Ref. Planning application No.A/114/17/PL to widen Hangleton Lane on the west side to enable large vehicle access on the east side.

BOTH MY WIFE AND I STRONGLY OBJECT TO THIS DEVELOPMENT THE REASONS LISTED BELOW.

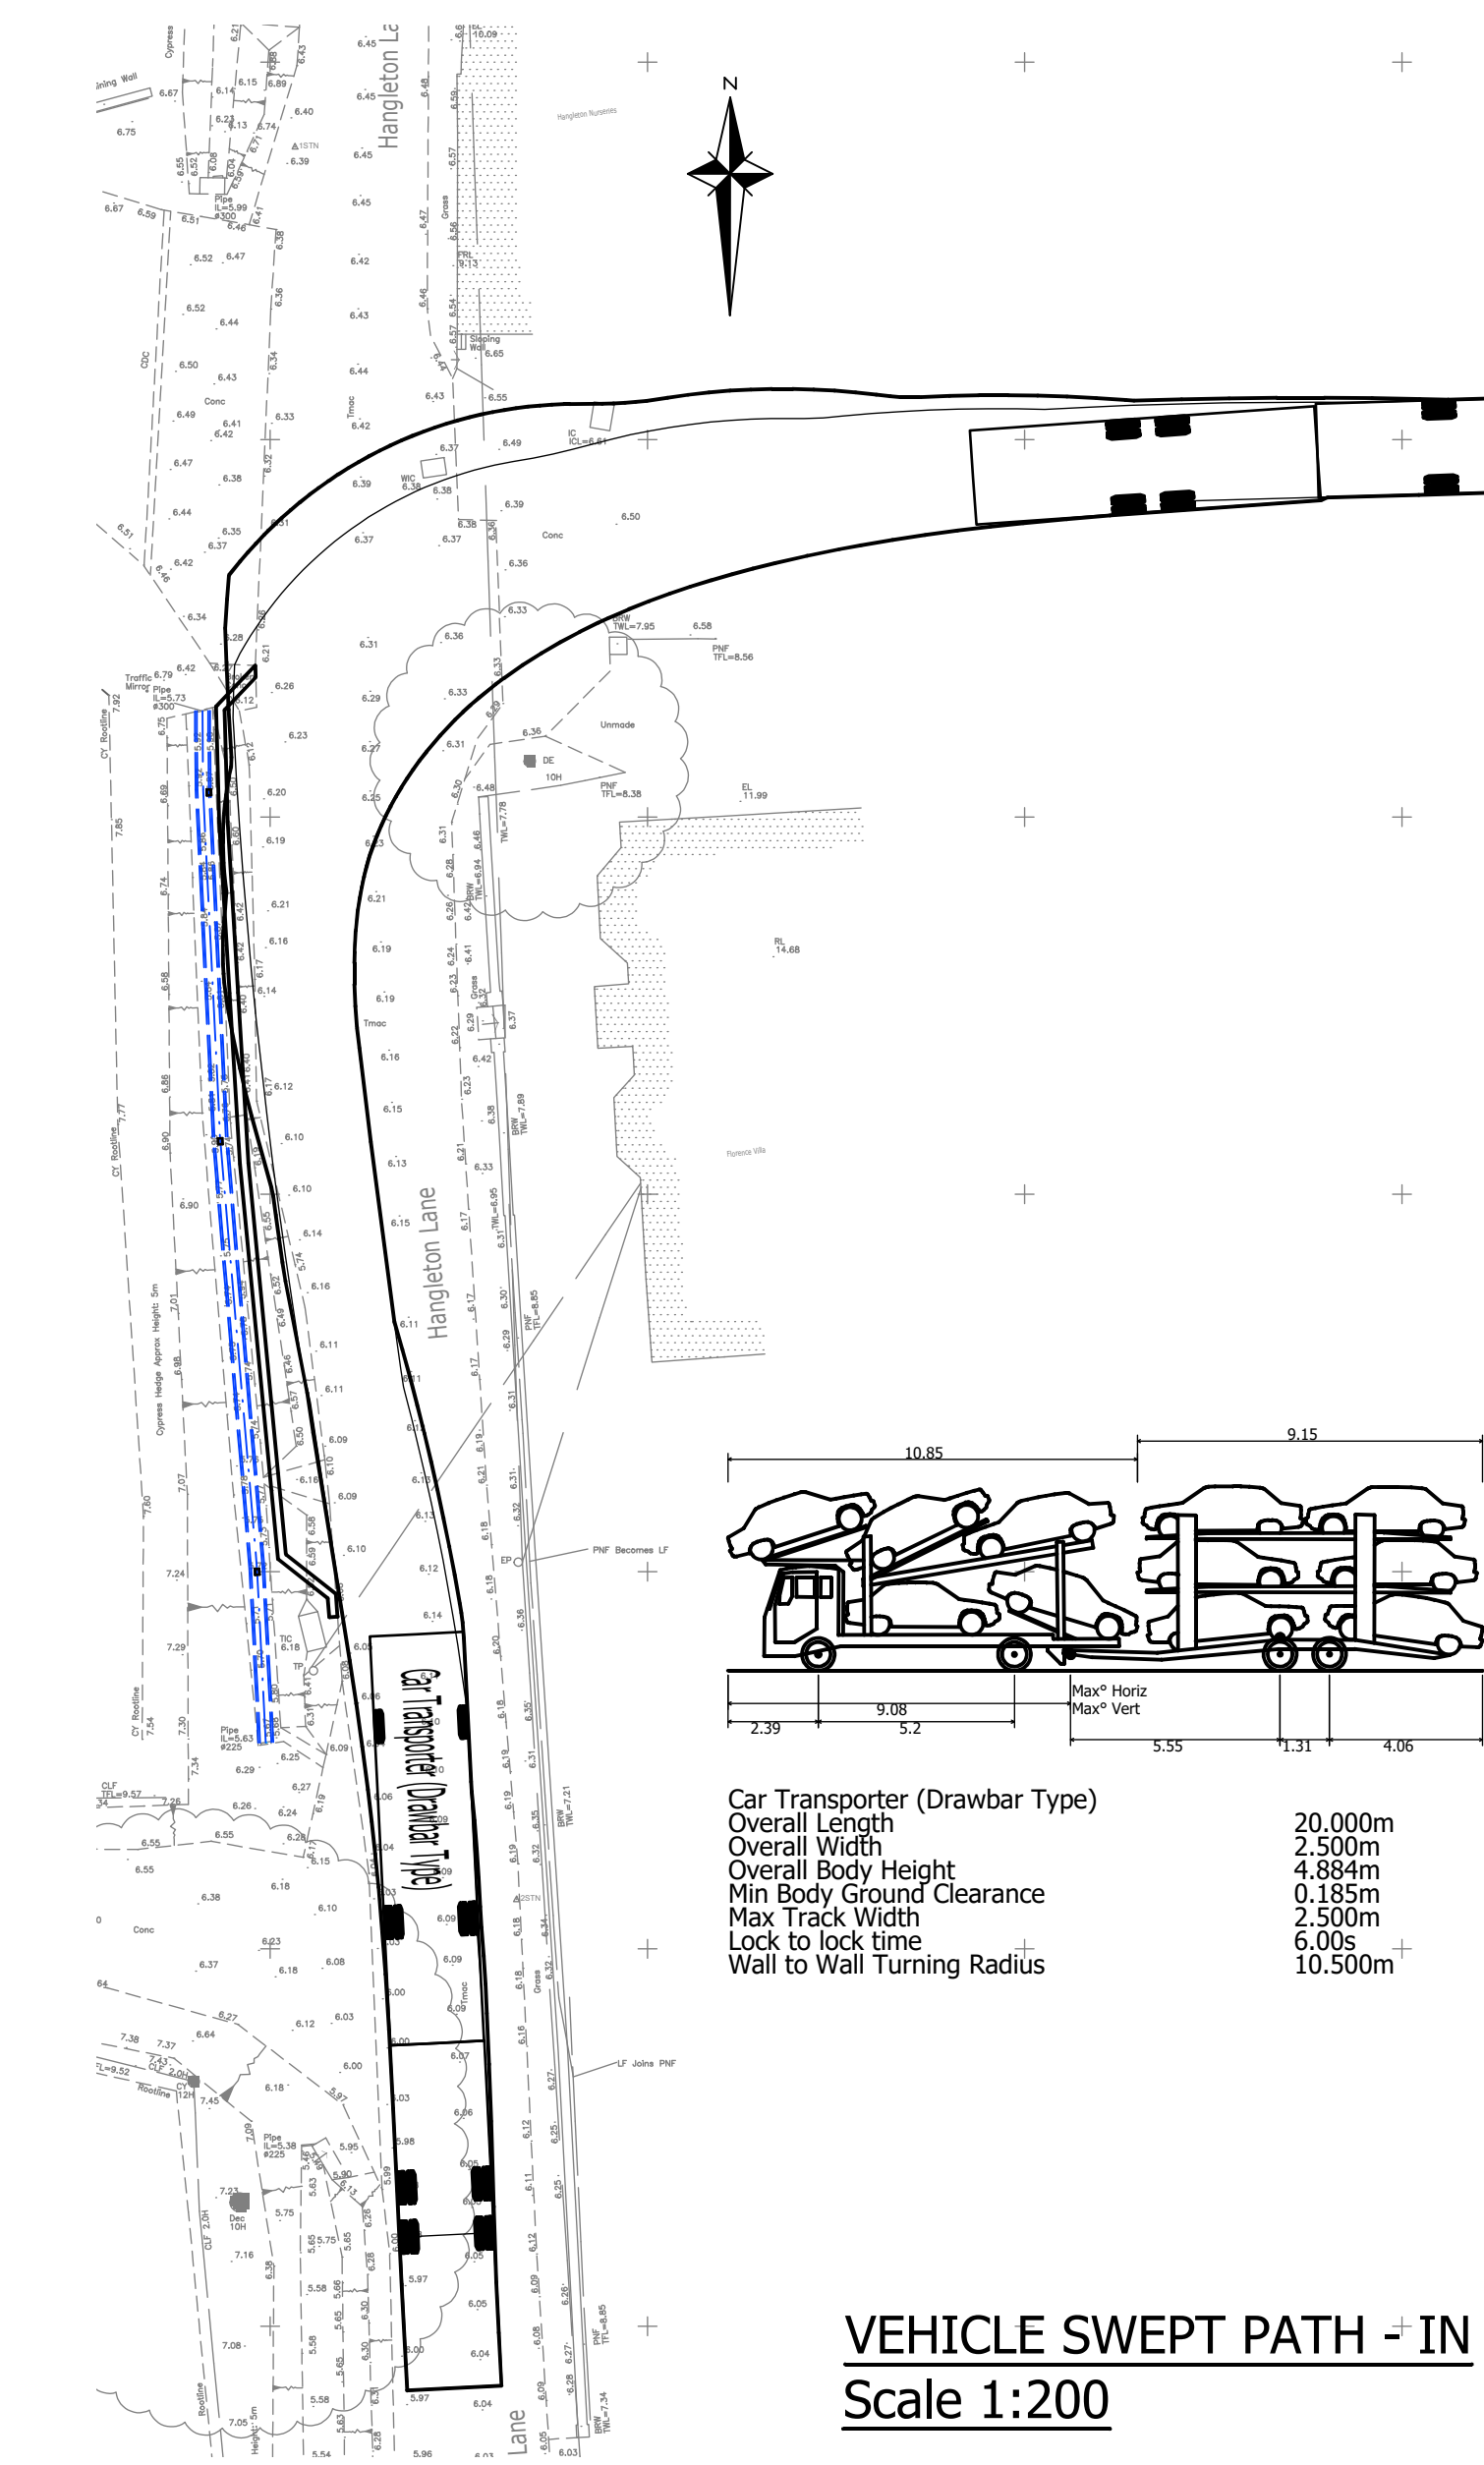
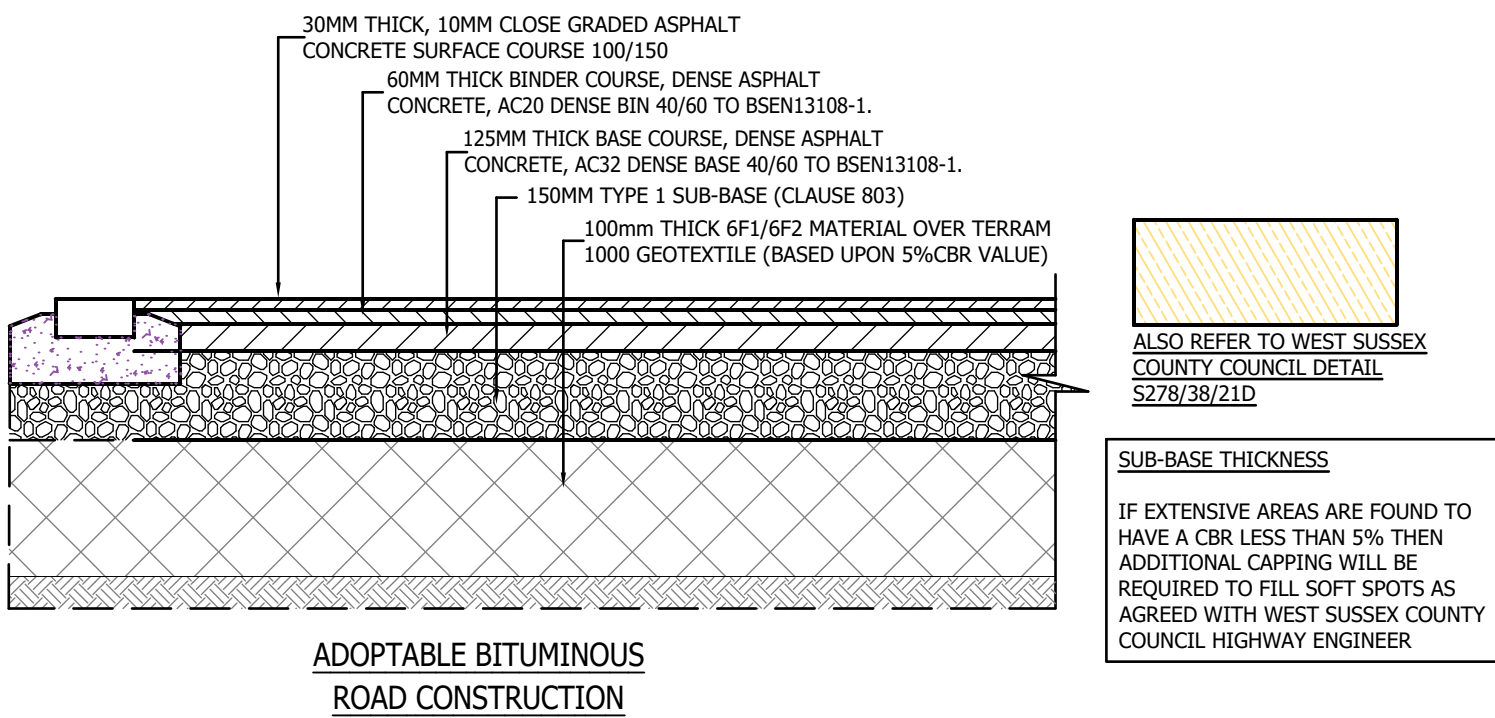
2. A large pull in on the west side of Hangleton Lane will only be used as a lay-by unless there is an entrance leading away from it which there won't be and why shouldn't it be used for parking (what is the difference between a pull in and a lay-by?)

If a vehicle is parked in this pull in we will be back to square one or even worse, If a transporter turns into Hangleton Lane to access this site and a vehicle is using it for parking where can the transporter go? it cant turn around in the Lane or reverse onto the A259 dual carriageway, it will just block the lane until the driver of the said vehicle is found!

3. Even with this pull in transporters will still have to use part of Cobbins Nursery roadway to get a hard right turn, has Mr Lisher the owner of Cobbins Nursery been consulted and given his permission because without this extra bit of Cobbins entrance road vehicles will still not be able to access Yeomans storage site.

4. Has any consideration been given to the retired Rev. & Mrs Glasier who live in Florence Villa on the south side of Yeomans storage site entrance, when they moved into Florence Villa this site was a working nursery with nursery type transport in and out not massive 50' transporters even with this pull in Mr & Mrs Glasier will not be able to relax in their own home, (these transporters will be very near their garden wall)

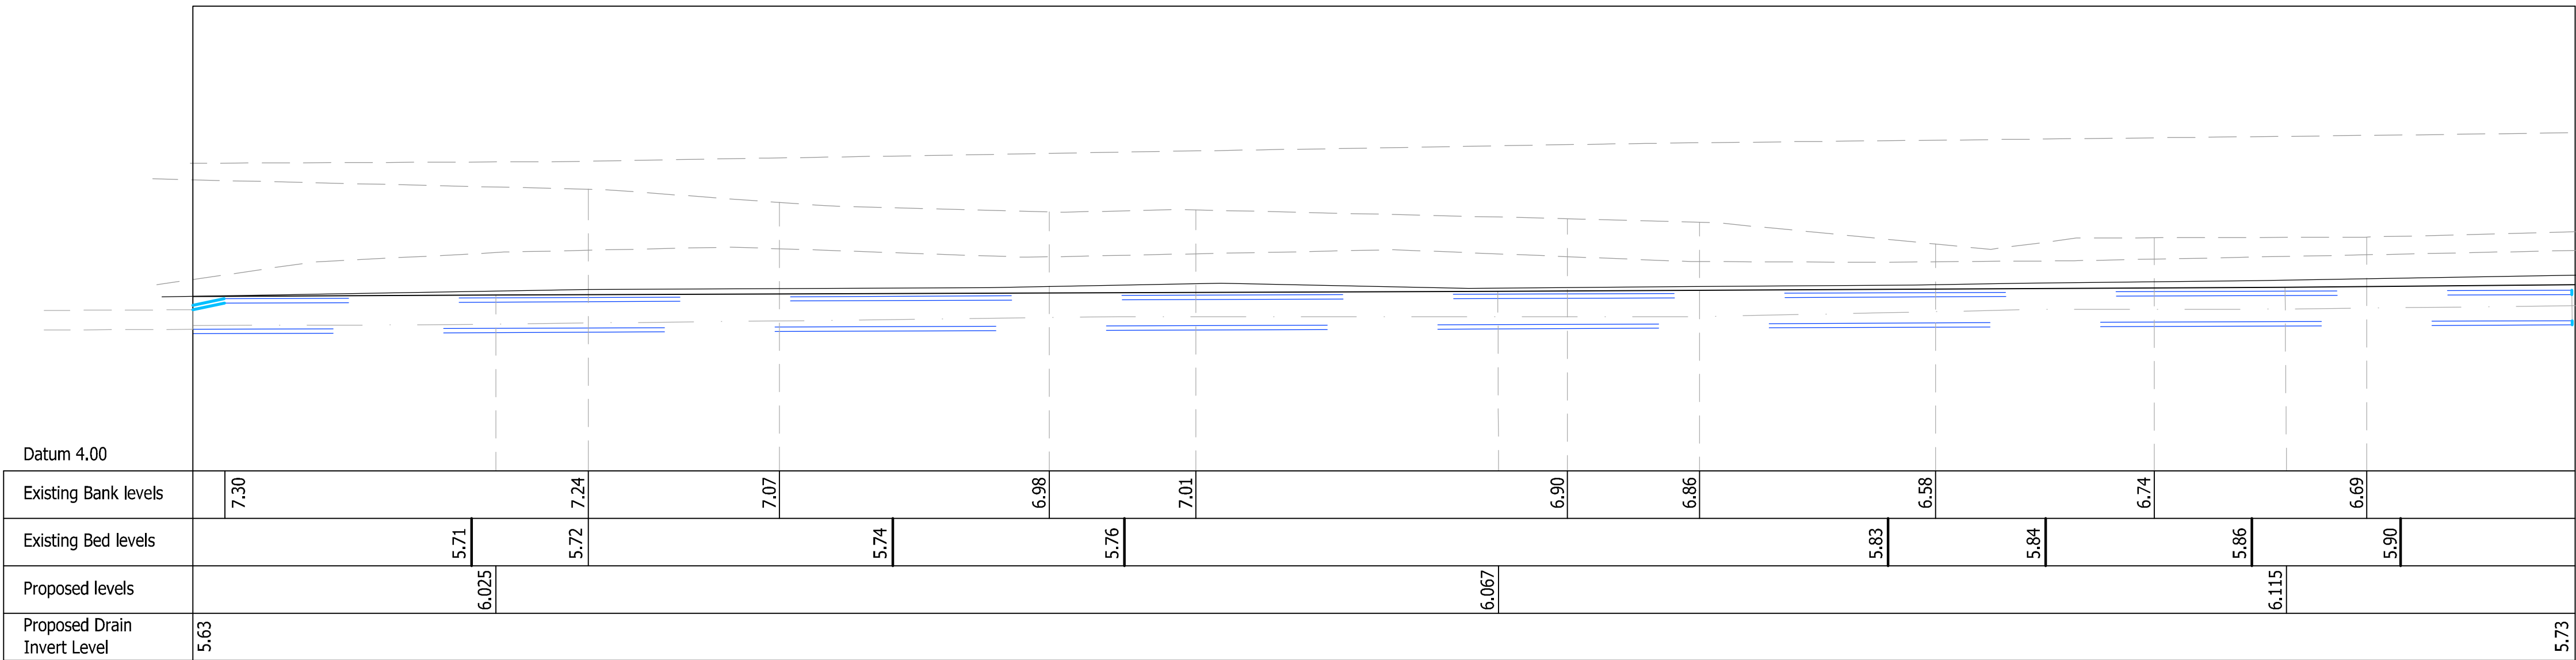
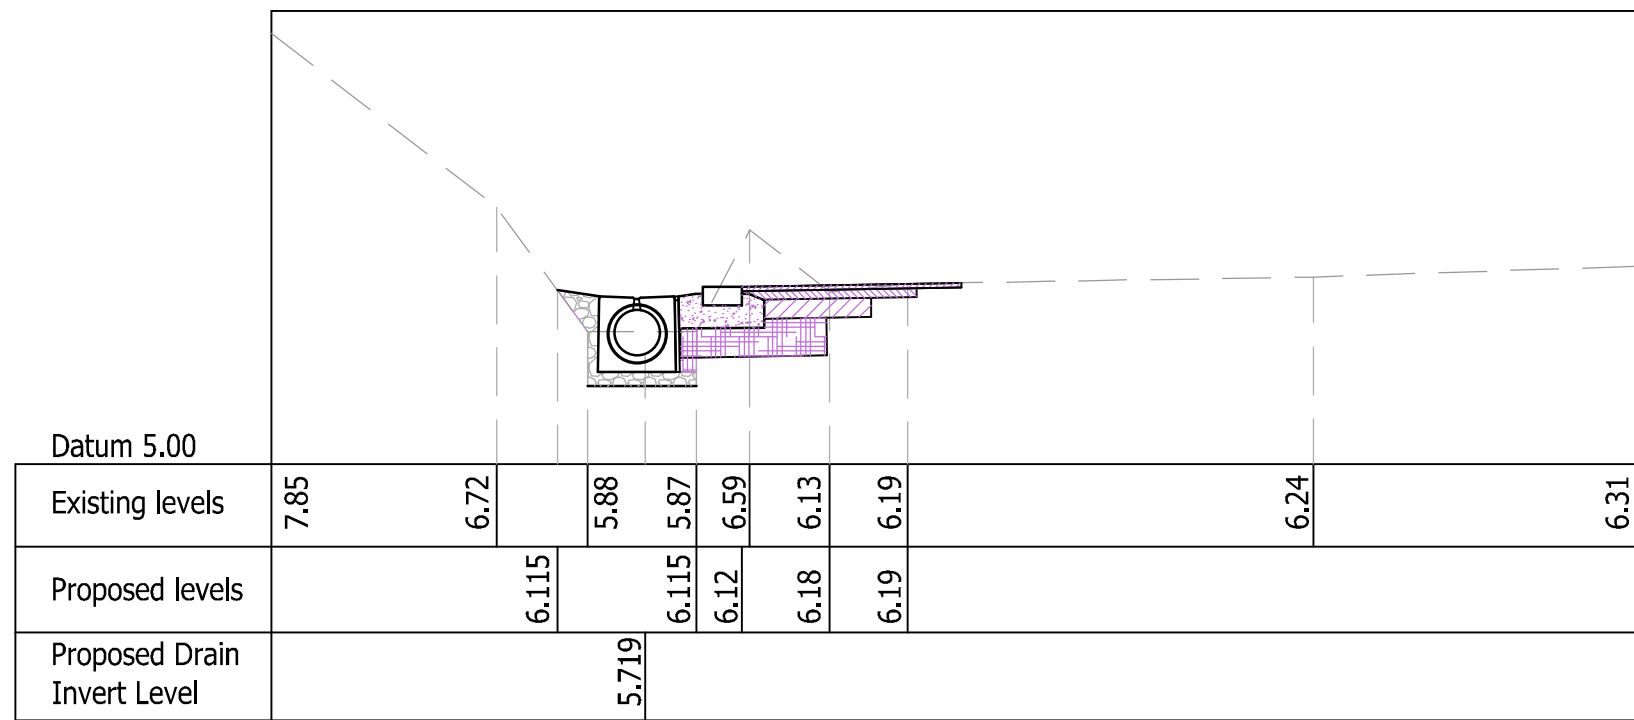
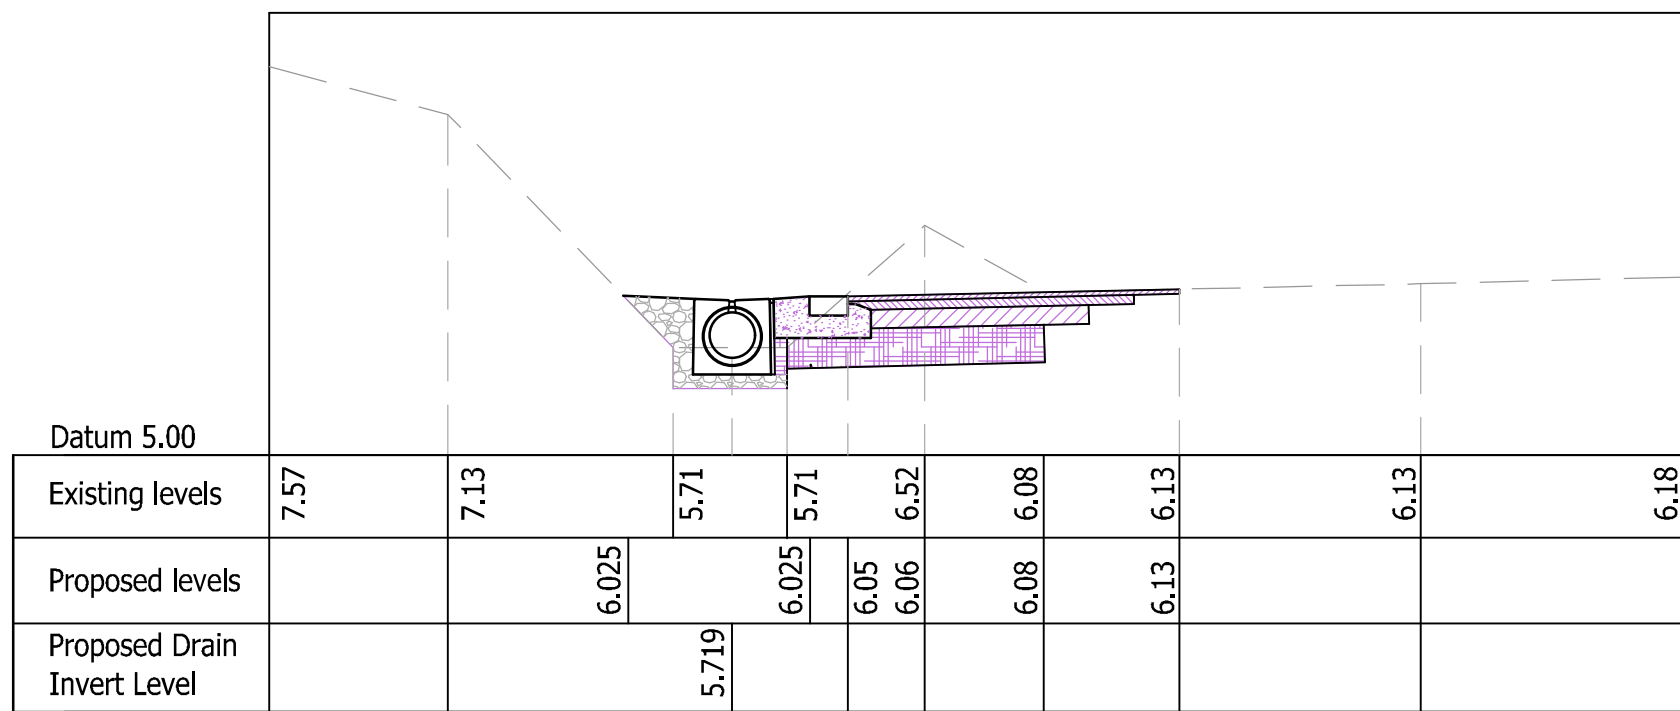
5. ADC are well aware we have a flooding problem at the bottom of the lane which they do nothing about! If this widening is allowed the ditch water will obviously be ducted under the concrete, this will be a considerable length which will be unclean able, when it has to be cleaned who would pay? ADC / the taxpayer / Cobbins Nursery or (JUST LEAVE IT BLOCKED) as will happen with the amount of silt and debris washed down from Highdown hill this ducting can be blocked even after one heavy downpour, all this just to please Yeomans
